# M5 Junction 10 Improvements Scheme

Statement of Common Ground  
Environment Agency  
TR010063 – APP 8.4

#### 8.3 Statement of Common Ground Environment Agency

Figure 2-2 River Chelt bridge cross-section

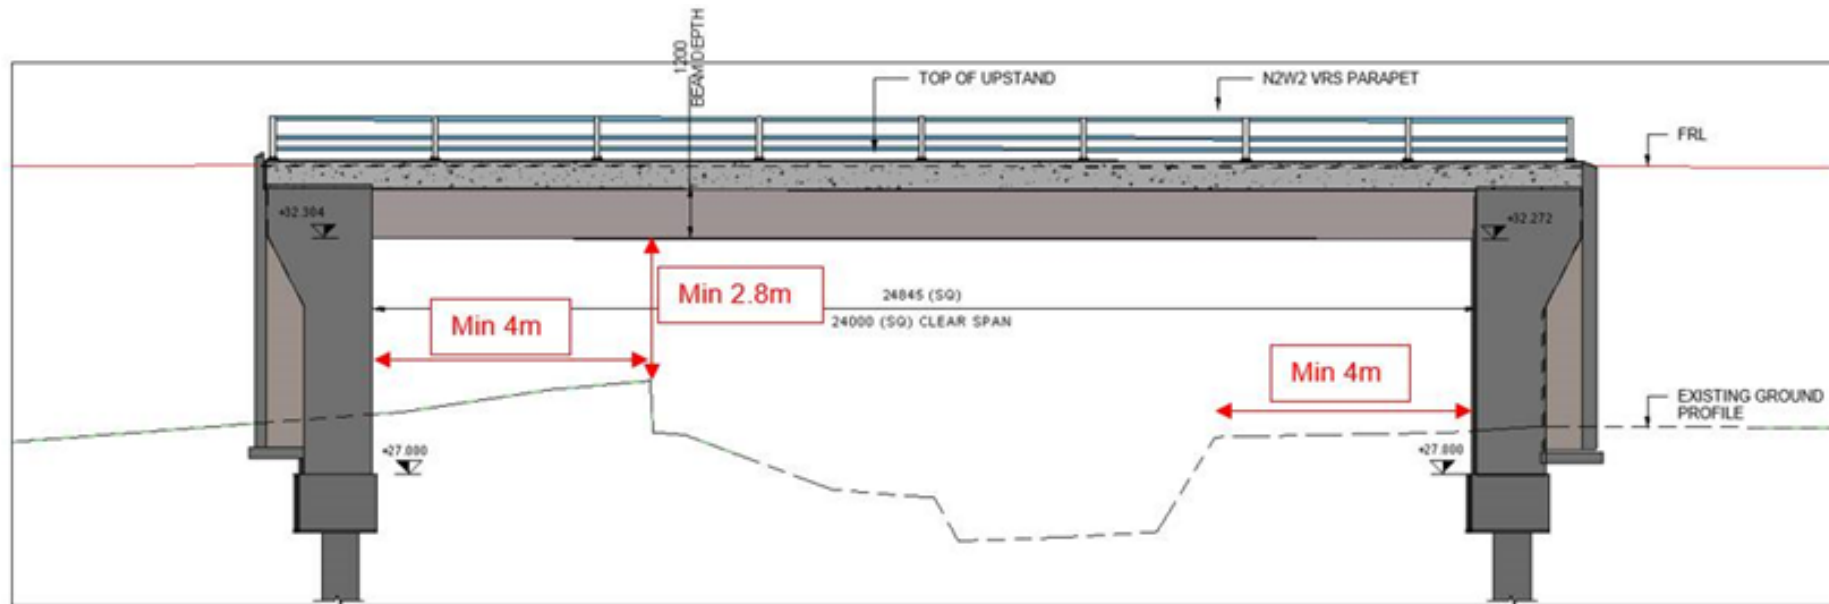
7.2.	<p>West Cheltenham Link Road River Chelt Bridge</p> <p>A single span structure is the preferred type of crossing to minimise impact on the water environment if designed appropriately. The EA welcome the clear span structure with no mid channel features with reduced interactions during the operational phase with the river bed and banks. However within the PEIR, there were conflicting descriptions of the geometry of the bridge in relation to the river. Whilst there will not be the direct permanent habitat loss and significant habitat severance associated with the culverting of the other watercourses there is potential for changes to riparian and associated flood plain quality and as well as water body hydromorphology leading to changes in river processes and habitats upstream and downstream.</p> <p>The Applicant has confirmed the structural dimensions of the proposed bridge (12.05.2022). The Applicant also acknowledged that based on indicative cross sections, the EA have requested greater variety in bank top to bank</p>	Matter agreed via EA review 07.06.2024.

Matter Reference number	Position	Date and method of agreement
	<p>top width to create a more geomorphologically interesting channel. At this time the drawings shared are concept plans and further work will be incorporated at that point to support detailed design (13.01.2023).</p> <p>At a meeting held on 05.06.2024, the Applicant confirmed that ref WE4 in the REAC details the geometry of the River Chelt bridge, therefore the EA are satisfied that there are no conflicting descriptions with regards to the bridge geometry. Refs WE3 to WE9 mentions measures to avoid deterioration to hydromorphology and ref WE15 states that works in the floodplain will be minimised as far as possible. Therefore, the EA are also satisfied that changes to riparian and flood plain quality and hydromorphology have been adequately addressed.</p>
